REFUSAL OF PLANNING PERMISSION

APPLICATION NO. 2018/0245

Proposal Erection of detached garage with store above and erection of boundary fencing and demolition of existing garage.

At 7 Burntwood Close, Thurnscoe, Rotherham, S63 0QQ

prop. front view. 1:100m view from ex garage nos.

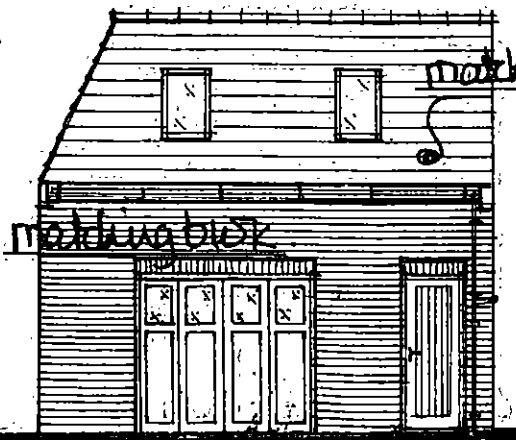
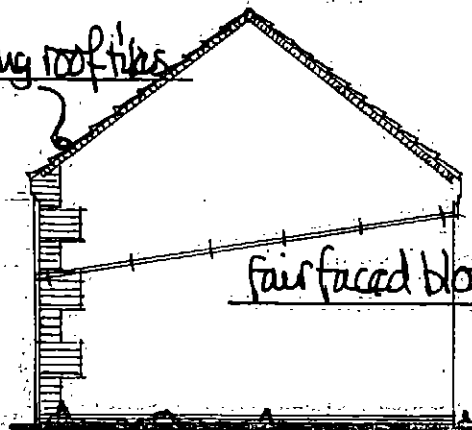
- 1 In the opinion of the Local Planning Authority the scale and design of the proposed garage is considered excessive in that it would not appear as a subservient feature to the host dwelling and would be overly prominent, to the detriment of the character and setting of the streetscene and the outlook of neighbouring properties from which it would be seen. As such the proposals are considered to be contrary to Core Strategy Policy CSP 29 (Design) and the design Guidance contained within Supplementary Planning Document - House Extensions.
